**DELEGATED DECISION FOR APPLICATION FOR CERTIFICATE OF LAWFUL  
DEVELOPMENT**

Reference no.: 2024/CL/90666/W

Site: 3, Wall Nook Lane, Cumberworth, Huddersfield, HD8  
8YB

Description: Certificate of lawfulness for proposed alterations to  
existing dwelling

Drg. no.
229-24-PL02

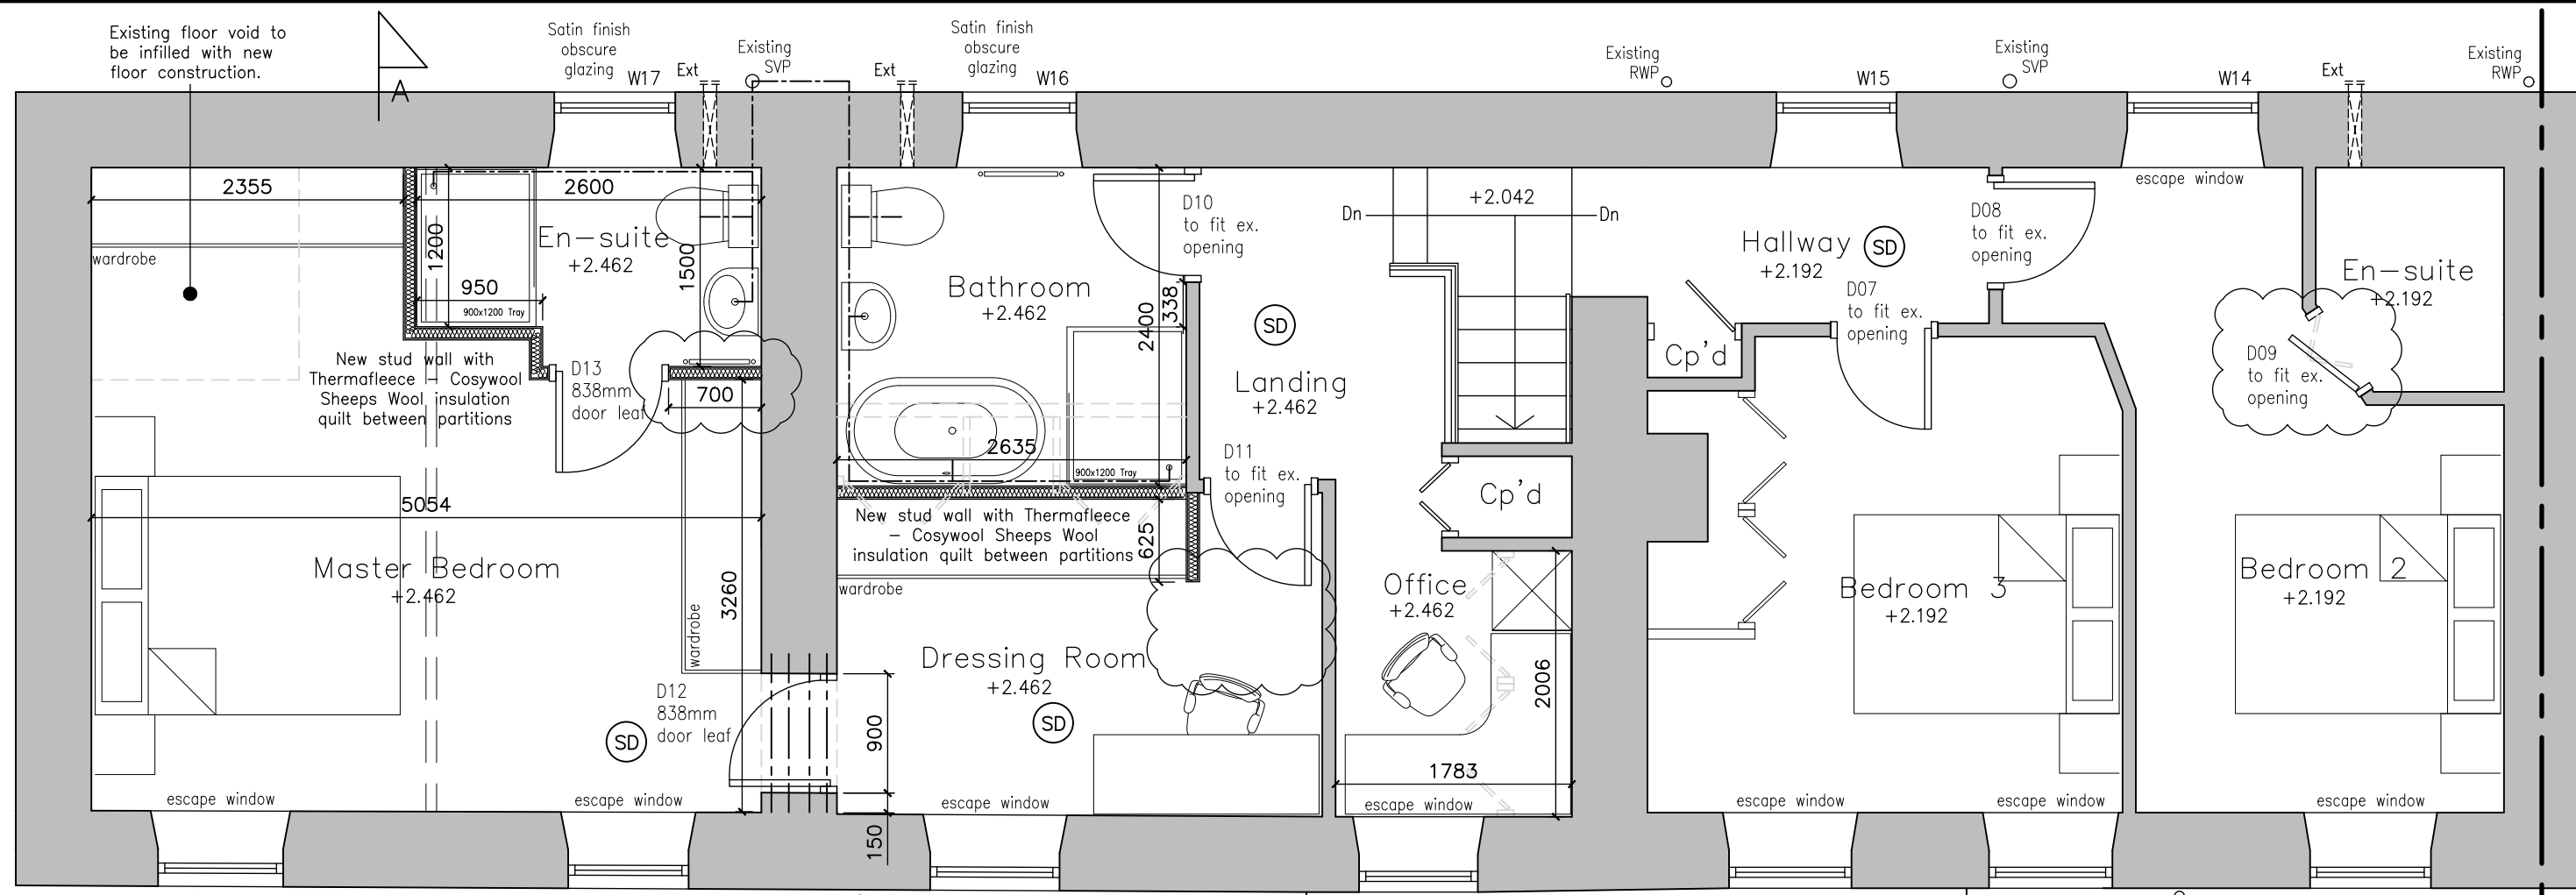
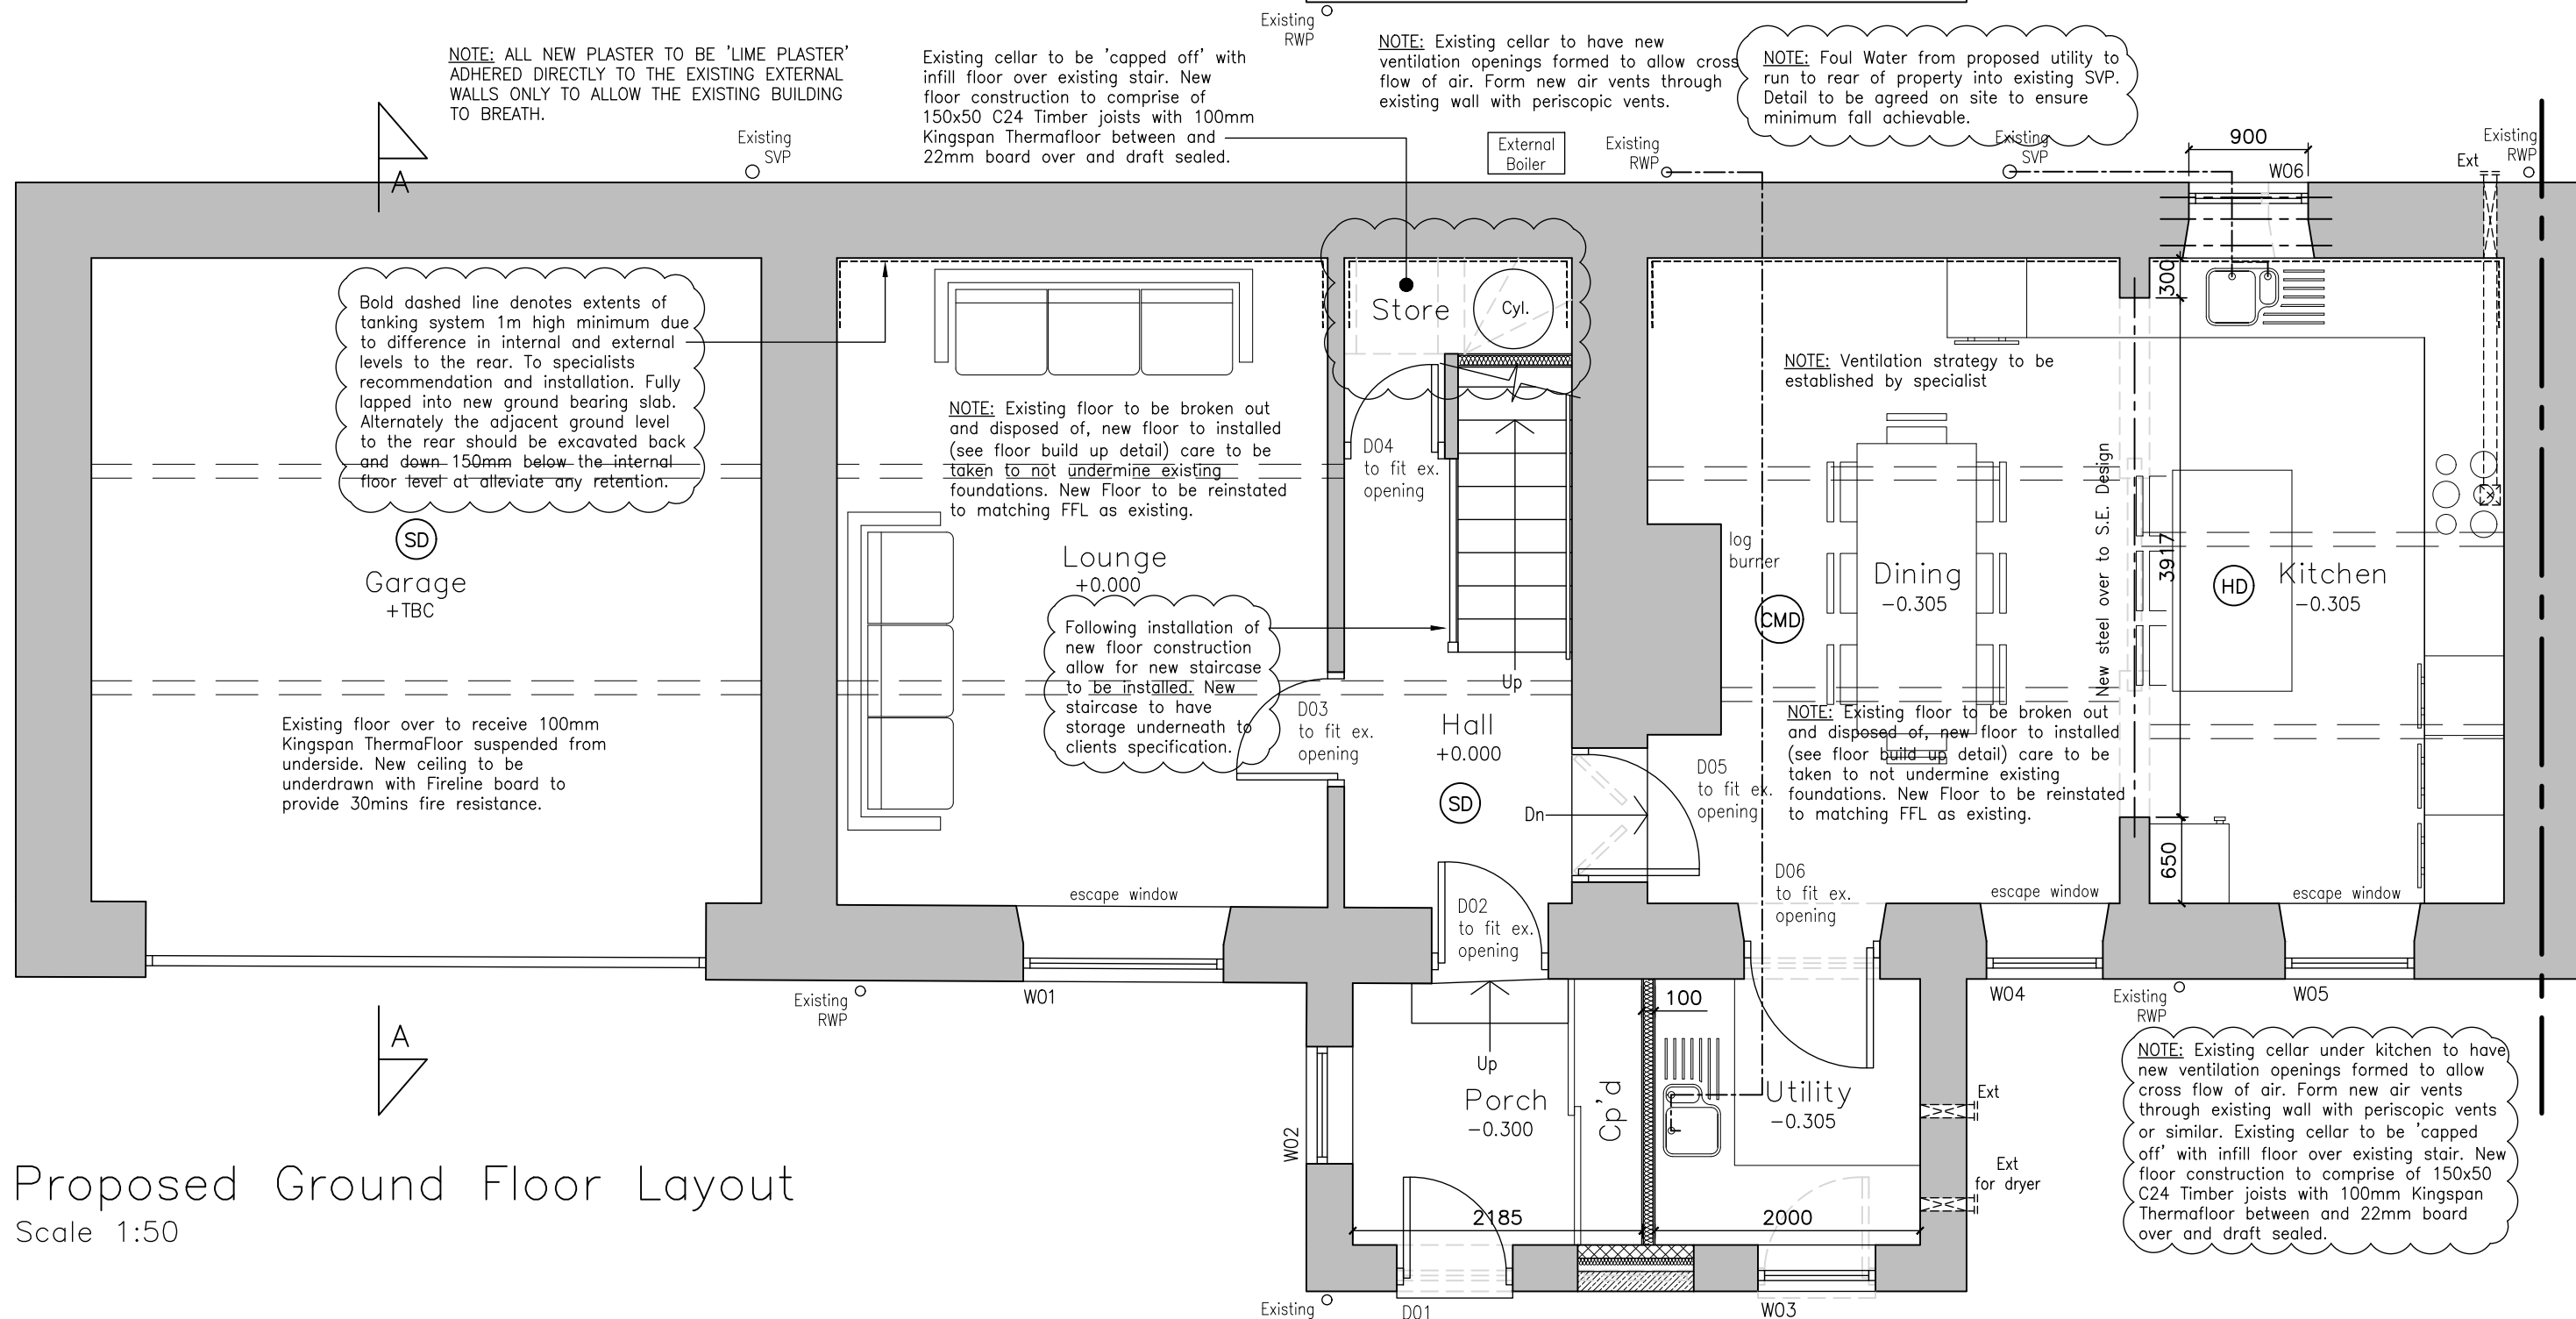
The proposal comprises internal alterations to form a master bedroom, en-suite, dressing room and office on the first floor and alterations to the flooring and addition of a new staircase on the ground floor. Additionally, it is proposed that the existing porch is divided to form a utility, which would result in the existing entrance door being replaced with a window and the existing porch window being made into the new main entrance. The timber windows are to be replaced by uPVC windows with the new first-floor en-suite and existing bathroom are to be altered so they are satin finish obscure glazing.

The proposed internal alterations to the dwellings are to affect only the interior of the building and the alterations to the existing openings do not materially affect the external appearance of the building. As such, the proposal is not regarded as being development as defined by Section 55 of the Town and Country Planning Act 1990.

The external alterations to openings and windows to composite doors and uPVC windows are likely to affect the appearance of the building to the degree the change in materials is likely to materially affect the character of the property. Permitted development rights under Class A may then apply.

granted under any class of Part 3, the heights of eaves and ridge are not altered and the development does not consist of any description of works in paragraph (k). Subject to materials matching the existing materials in appearance, the proposed external alterations benefit from permission granted under the provisions of the GPDO.

The proposed internal alterations as shown on plan 229-24-PL02 Rev C are not development as defined under Section 55 of The Town and Country Planning Act 1990 and the proposed external alterations to windows and door openings benefit from a general planning permission granted by virtue of Article 3(1) and Schedule 2, Part 1, Class A of the Town and Country Planning (General Permitted Development)(England) Order 2015 (as amended) subject to conditions as stated in paragraph A.3 of the same Order.
